Southampton to London Pipeline Project

Responses to ExA's Further Written Questions -
Queen Elizabeth Country Park (QE)

Application Document: 8.42

Southampton to London Pipeline Project
Response to the Examining Authority's Further Written Questions – Queen Elizabeth Country Park (QE)

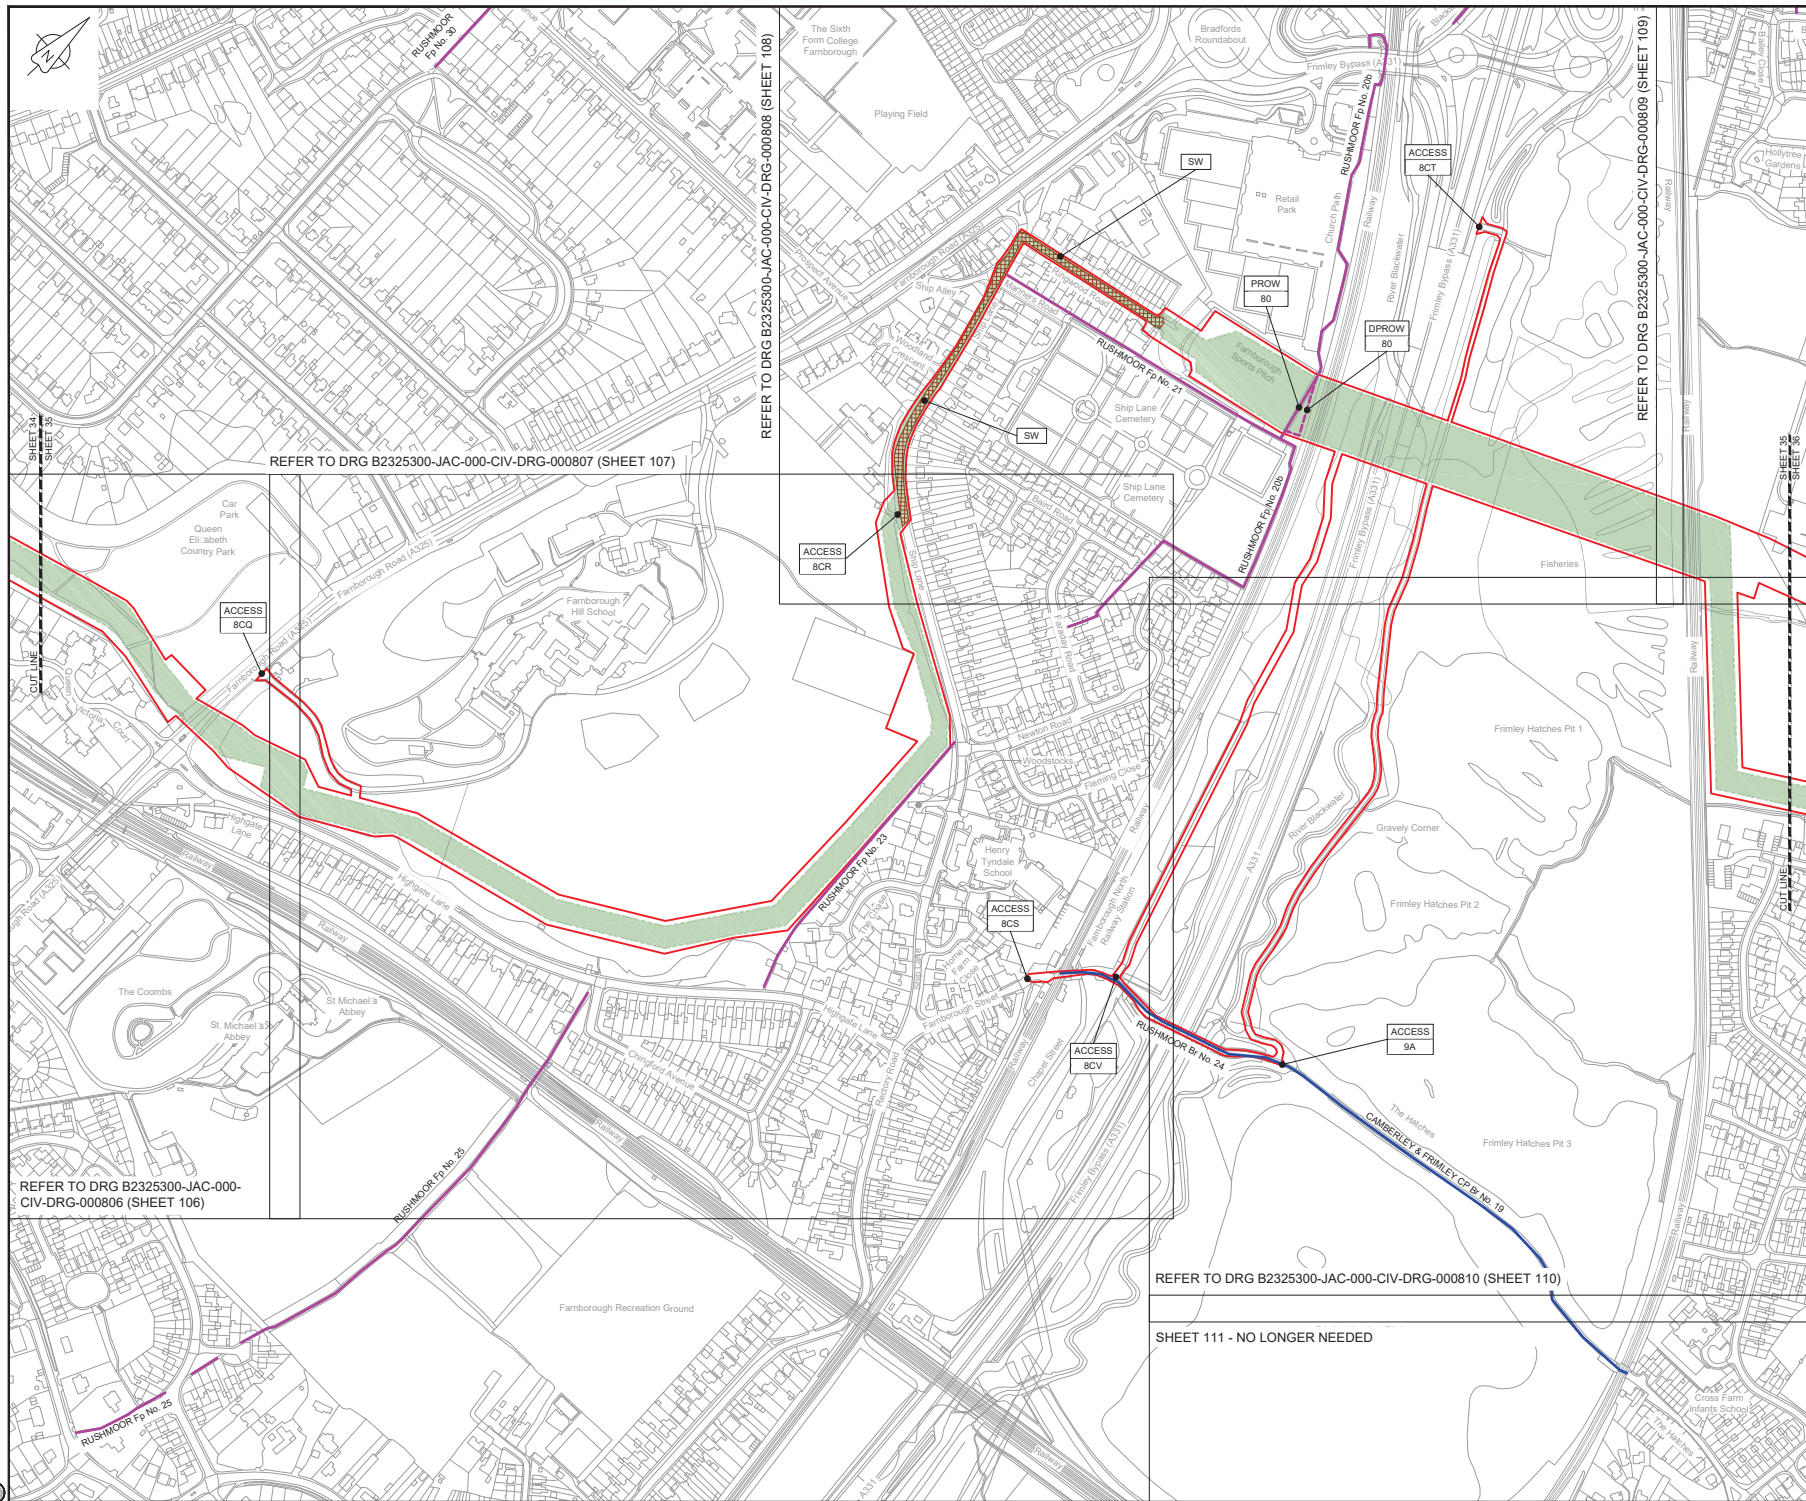
ExQ2	Question:	Applicant response to Question:
QE.2.7	<p>Figure 1.5 of the Applicant's responses to Other Parties submitted at D3 [REP3-017] indicates the proposed temporary access from Farnborough Road to the auger drill compound in Queen Elizabeth Country Park. This proposed temporary works access has been added to the dDCO [REP3-006] but is not shown on the relevant Access and Public Rights of Way or Works Plans.</p>	<p>1.1 The Applicant confirms that the proposed temporary access (Work No 8CZ) from the A325 – Farnborough Road to the auger bore area is now shown on the Work Plans and Access and Public Rights of Way Plans (See Appendix QE.2.7.1 and QE.2.7.2).</p>
